# SPR EA1N and EA2 PROJECTS

## DEADLINE 5 – POST HEARING SUBMISSIONS (ISH4)

**Interested Party:** SASES

**Date:** 3 February 2020

Plate 9.1 Flow chart summarising the Applicant's application of the SuDS hierarchy and strategy post-consent

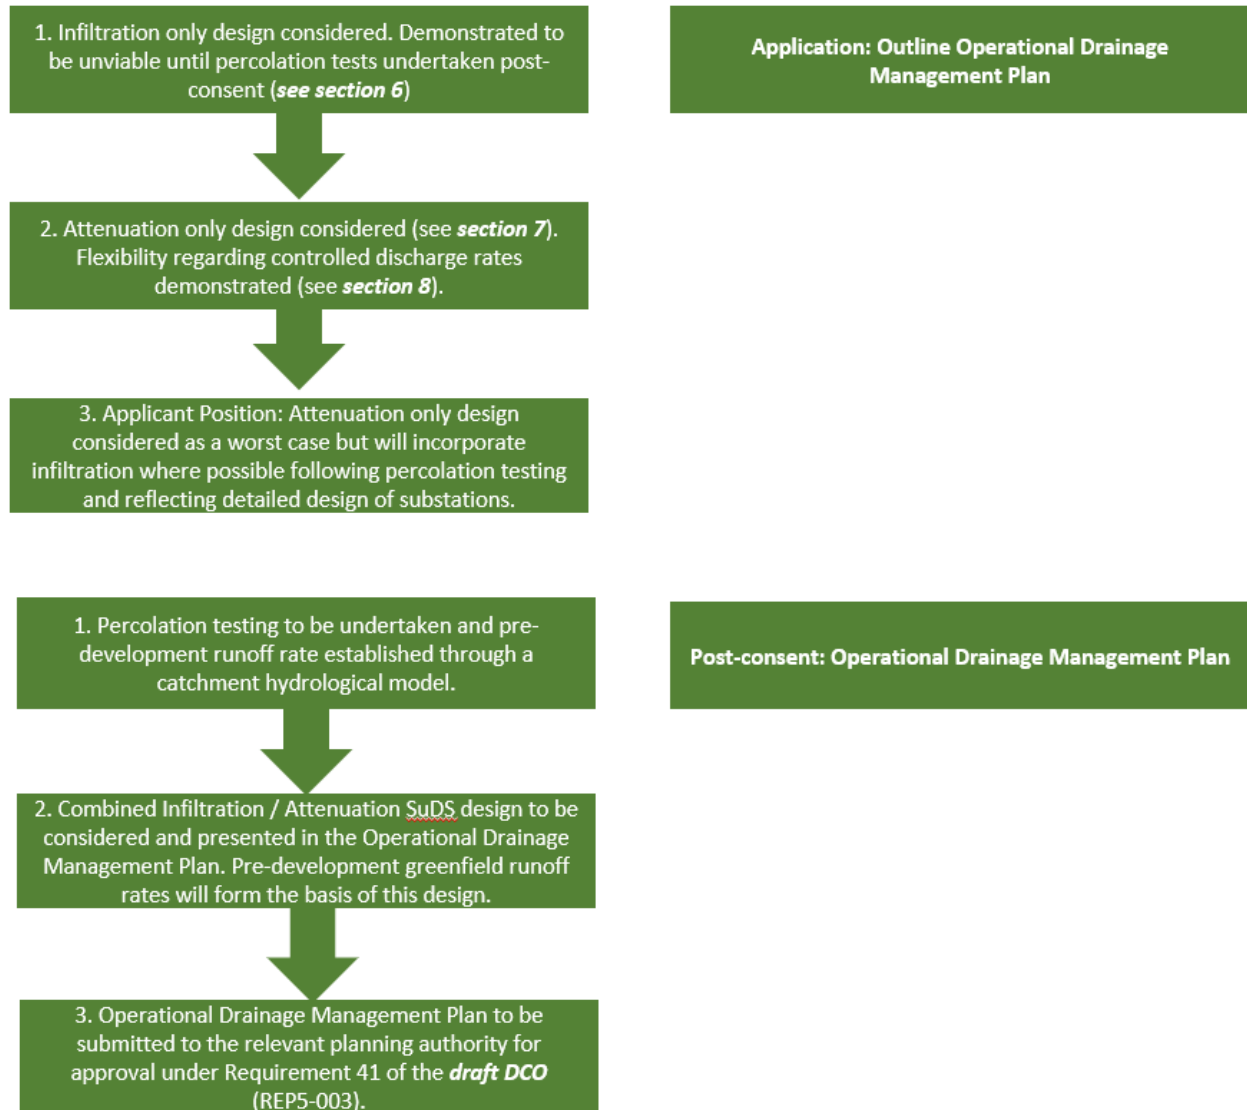
7. As to scheme design, the applicant has failed to demonstrate that there is a viable infiltration solution for operational surface water management. The infiltration rate of 10mm/hour is used to assess whether it is possible to get water into the ground at all: it is an assumption. The applicant has in fact failed to demonstrate that an infiltration rate as high as 10mm/hr actually exists on site. Infiltration rates in the natural environment can vary by more than six orders of magnitude. This leads to consideration of the factor of safety (FOS). The sensitivity analysis by the applicant is inadequate. It should use a FOS of 10 (as is used on the outputs of the model) for the inputs from the source. Accordingly, without using an appropriate FOS and without undertaking infiltration testing, there is a significant constraint on the confidence to the sizing of the storage volumes required to provide storage for infiltration or for discharge to the watercourse.

9. Such a scheme design will have to work for both peak and total flows and across a range of design periods. The scheme design will have to work for the 1:100 year flood event, but also for the 1:30 and 1:1 year event. The applicant does identify the “Qbar” flow (1 in 2 year return period) which will be released from the attenuation lagoons, but there are no details on the scheme required to enable that discharge to be achieved. There are no details of infiltration rate, floor area, volume, inflow design storm(s), FOS, emptying times etc.

10. The applicant’s calculations show the required storage volume in the operational ponds exceeds the design volume by 50% and relies on “freeboard” and landscaping to provide the reported required volume to prevent over-topping. [The freeboard is the additional volume beyond that required for the design storm and is required to allow for other uncertainties (e.g. wave action due to high winds etc).] It must not be used to accommodate the design flood itself.] The applicant’s methodology is an unacceptable approach.

11. The attenuation ponds are above ground level on their downslope sides, meaning tens of thousands of cubic metres of water could be released into Friston if there is an uncontrolled overtopping and/or failure of the pond bunds. No reservoir inundation modelling has been undertaken, and no consideration has been given of the consequences of such a failure.

12. The most recent submissions at Deadline 4 (Outline Operational Drainage Management Plan and Outline Code of Construction Practice) contain insufficient detail or analysis to demonstrate that: flood risk has been adequately assessed; that the surface water schemes are viable; and that they will achieve adequate flood risk mitigation.
